**Our ref:** AE/2021/126117/01-L01  
**Your ref:** \*  
**Date:** 25 May 2021

**THURROCK FLEXIBLE GENERATION PLANTS - PROPOSED MATERIAL CHANGE TO SCHEME.**

**LAND NORTH OF FORMER TILBURY POWER STATION, TILBURY, ESSEX**

Thank you for the opportunity to consider the Proposed Material change to the Thurrock Flexible generation Plant, as set out in your letter dated 21 May 2021. We have reviewed the new information that has been submitted and have provided further comments in regards to flood risk related to the proposed culvert and ecology.

Figure 3.1: Alternative AIL Access – Western Section

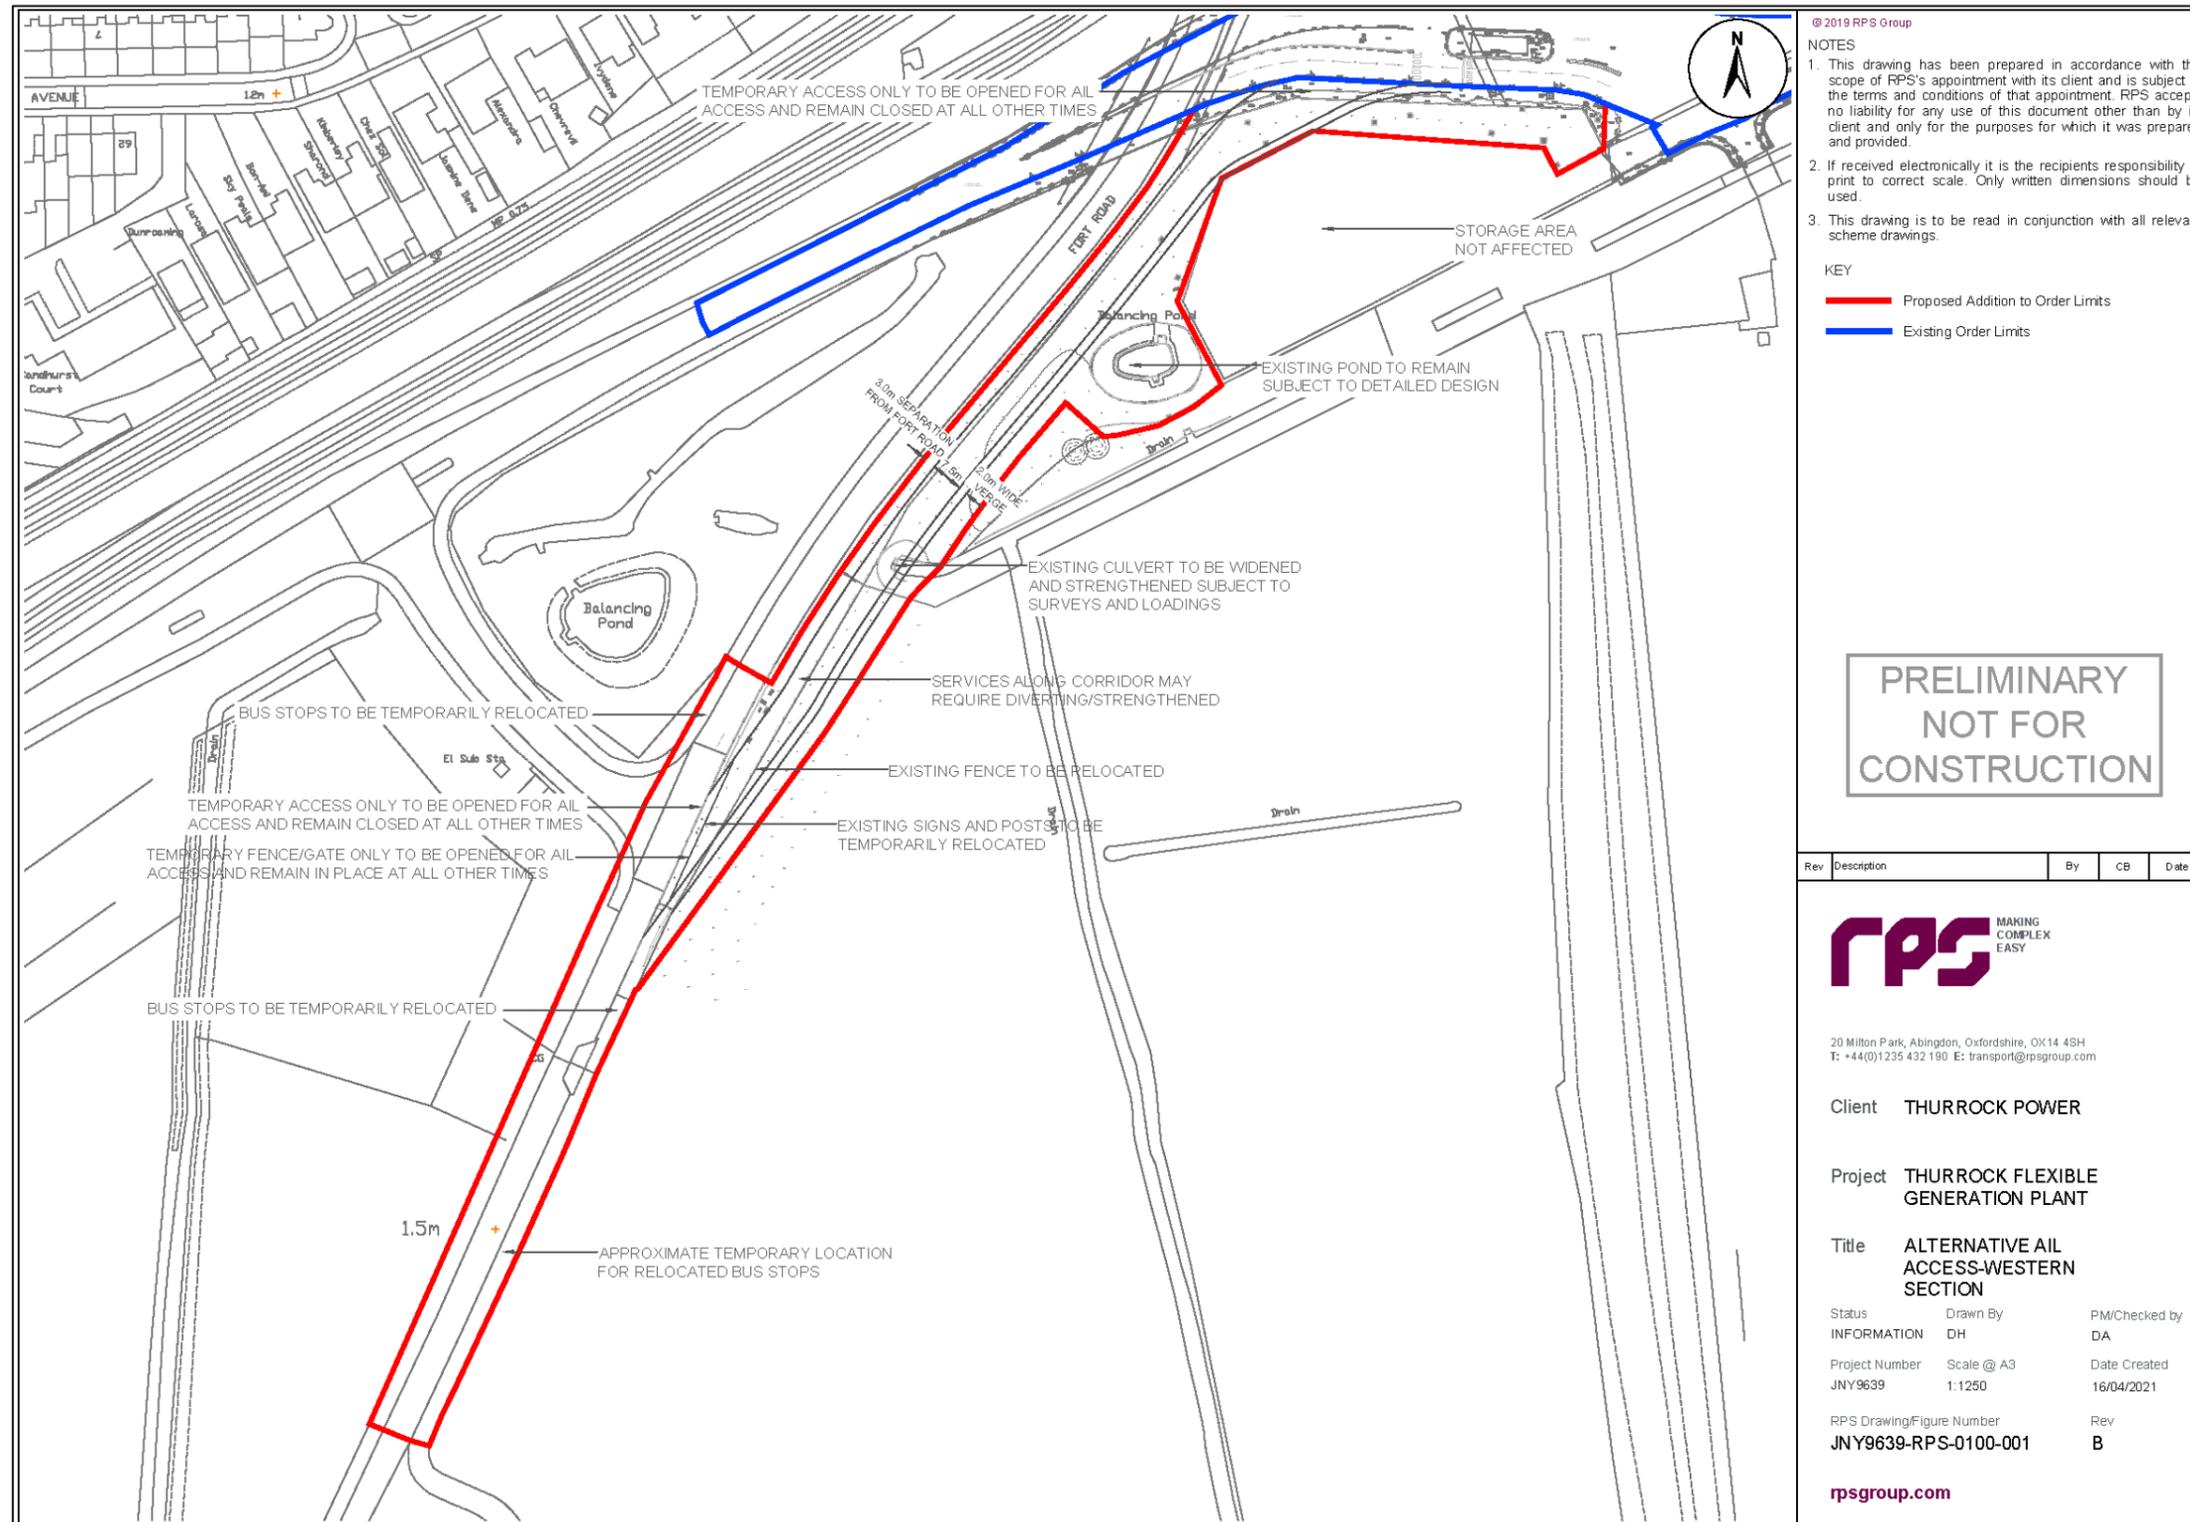
The existing culvert beneath Fort Road (at approximately TQ6522776141) is proposed to be extended in length by 5 metres, the location of which is detailed in figure 3.1: Alternative AIL Access – Western Section, RPS drawing number JNY9639-RPS-0100-001, revision B, within the Environmental Statement Addendum – Alternative AIL Access, dated April 2021. We do not have any objections in principle to the extension of this culvert, or to the possible need to widen and strengthen the existing culvert in principle. Details/permits will need to be agreed in due course.

The applicant should ensure that the proposed culvert is passable for water voles and fish, and this should be built into the design. The loss of any watercourse would need to be offset, through the creation of a new ditch within the red line boundary.

Figure 3.2: Alternative AIL Access – Eastern Section

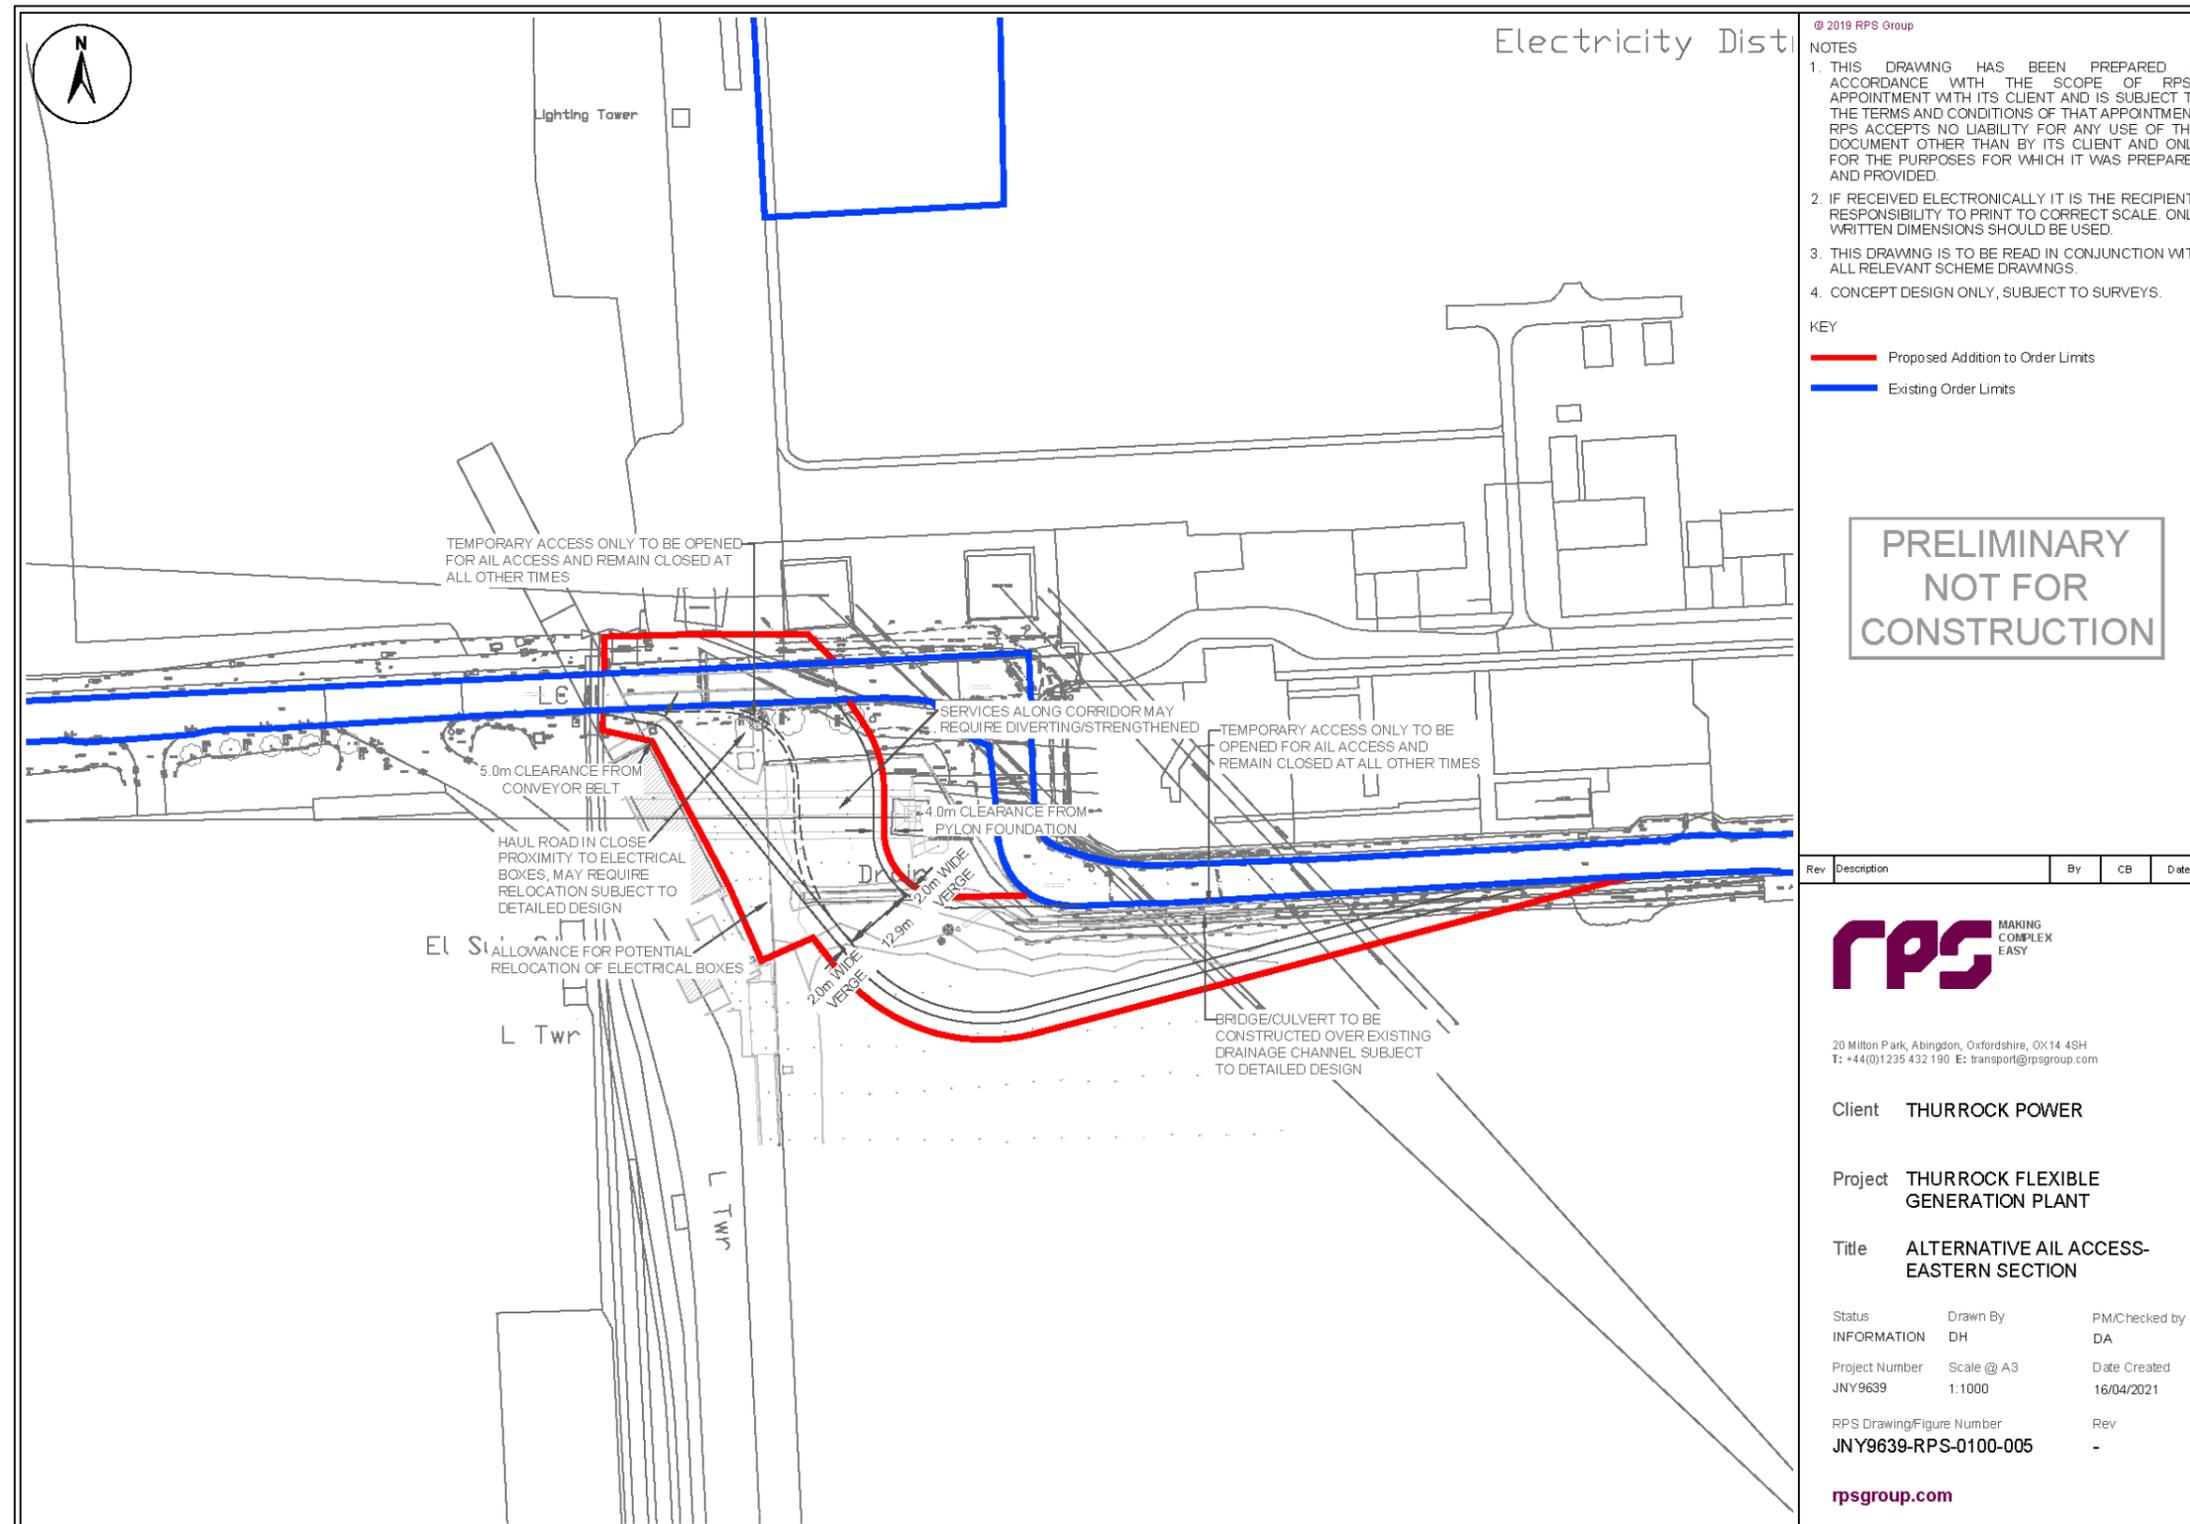
The proposed culvert construction and infilling of a watercourse to allow for the modifications to the road to accommodate AIL access on the Eastern Section involve an ordinary watercourse, and are therefore fall outside of our permitting requirements.
